KIRKLEES METROPOLITAN COUNCIL INVESTMENT & REGENERATION SERVICE

DELEGATED DECISION TO DETERMINE PLANNING APPLICATIONS

Reference No:	2025/62/90024/W
Site Address:	2, New House Farm, Shaw Lane, Holmfirth, HD9 2PY
Description:	Erection of first floor side extension
Recommending Officer:	Molly Storer

HOUSEHOLDER DELEGATED REPORT

Title: Proposed Plans and Elevations
#

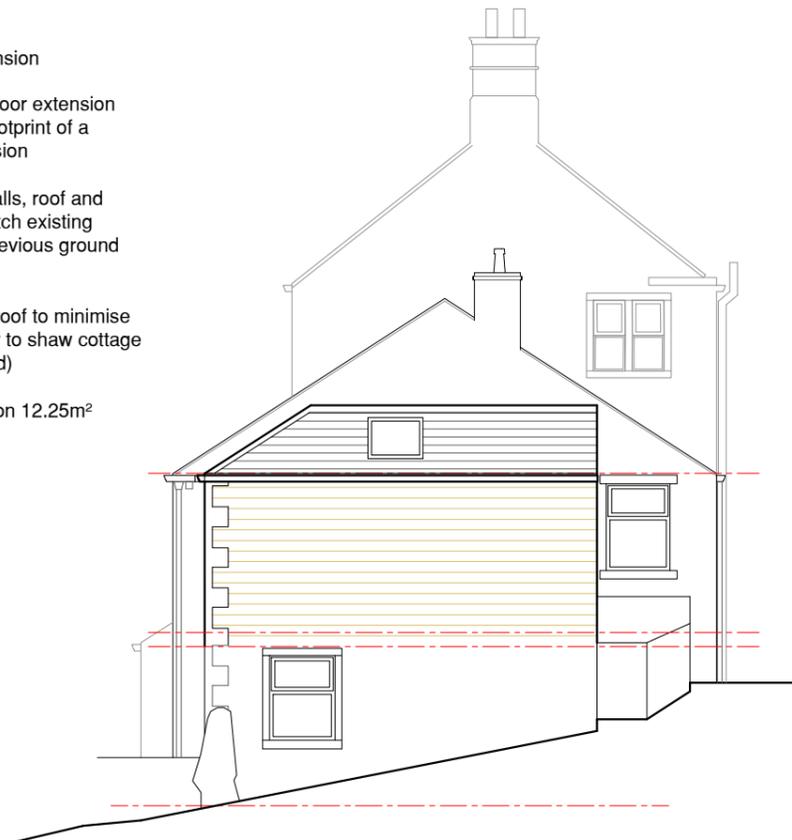
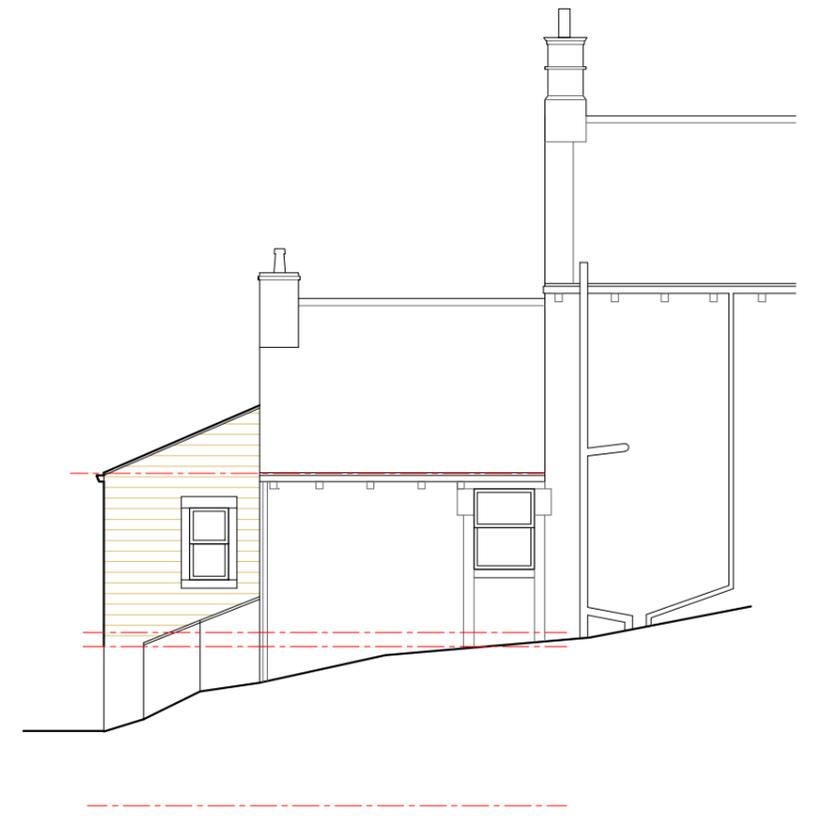
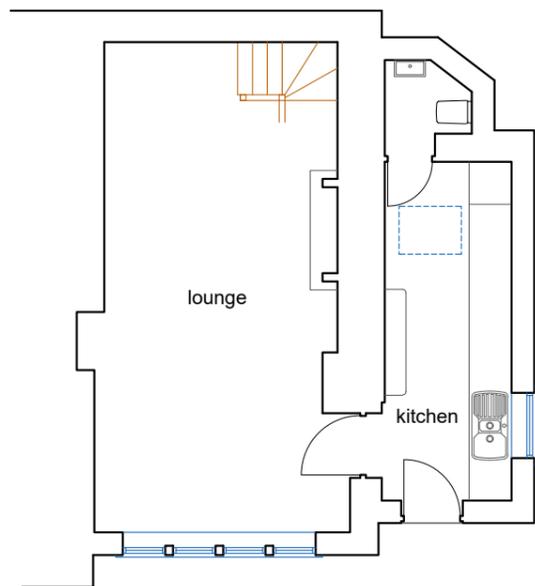
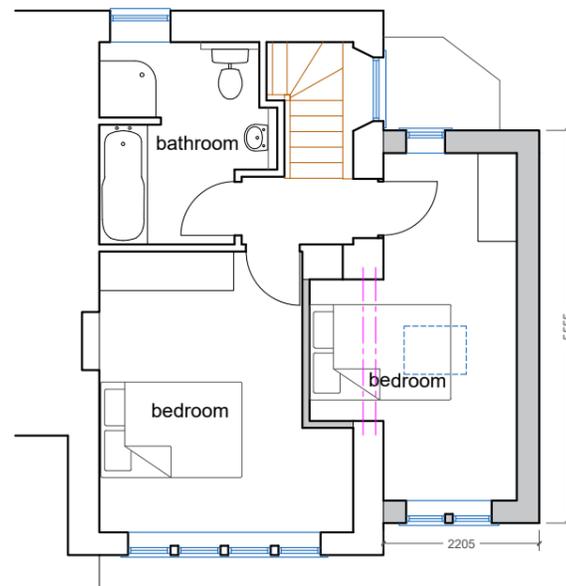
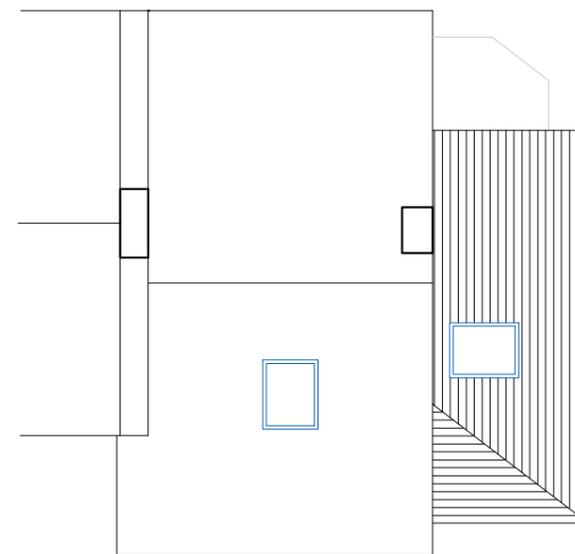
The extension will project 2.205m from the first floor of the northeast elevation above an existing sideward projection. It will have a width of 5.5m and will have an overall height to the eaves of 4.8m with an overall height of 5.7m.

The roof form will be a part hipped part lean to and the extension will be constructed from stone with a slate roof to match the existing property.

Relevant key design principle (KDP) of the SPD, Policy in the Kirklees Local Plan and the NPPF	Further comments	✓ / X / N/A
Impact on the Local character and street scene	• KDP1 of the SPD • Policy LP24 Design (a) and (c) of the KLP • Chapter 12 NPPF • Policy 1 & 2 of the HVNDP	Limited impact on the street scene due to being set back from the adopted road (Shaw Lane) and being constructed from materials which harmonise with the original dwelling. The other terraces along this row are 3 storeys high meaning that the development which will bring the single storey element up to 2 storeys (on the hosts 2 storey dwelling) and will still be set down from the existing dwelling will not result in a harmful impact.	✓
Impact on original house	• KDP2 of the SPD • Policy LP24 Design (c) and (d) of the KLP • Chapter 12 of the NPPF	Considered to be acceptable on the basis of being set down and set in from the existing property. It is noted that the roof design will differ from the	✓

Roof style	- KDP 1 and 2 of the SPD - Policy LP24 Design (a), (c) and (d) of the KLP - Chapter 12 of the NPPF - Policy 1 & 2 of the HVNDP	The roof design will differ from the existing property however on balance this is considered acceptable due to the mix of roof types in the wider locality such as the catslide roof and hipped roof elements opposite the side elevation and the lean to roofs to the front of the rest of the row of terraces.	✓
Window proportions	- KDP 1 and 2 of the SPD - Policy LP24 Design (a), (c)	There is proposed to be an additional window to the front and rear of the extension and a single rooflight in the roof slope	✓

Impact on privacy of neighbours (to sides, rear and front)	• KDP 3 & 4 of the SPD • Policy LP24 Design (d) (iv) • Chapter 12 of the NPPF • Policy 2 of the HVNDP	There are no windows proposed in the northeast facing side elevation. There is a window located in the roof slope however given the separation distance to Ash Villa of ~6m this is not considered to cause a significant level of overlooking.	✓
Impact on light and outlook of neighbours (to sides, rear and front)	• KDP 4, 5, 6 of the SPD • Policy LP24 Design (b) • Chapter 12 of the NPPF • Policy 2 of the HVNDP	Ash Villa is located at a separation distance of ~6m away from the extension and is located on a higher ground level than the host property. It is therefore considered that there will not be a significant impact upon the amenity of neighbouring occupiers in this regard, particularly taking account of the size / scale of the proposal and the relationship between these buildings is slightly off set.	✓
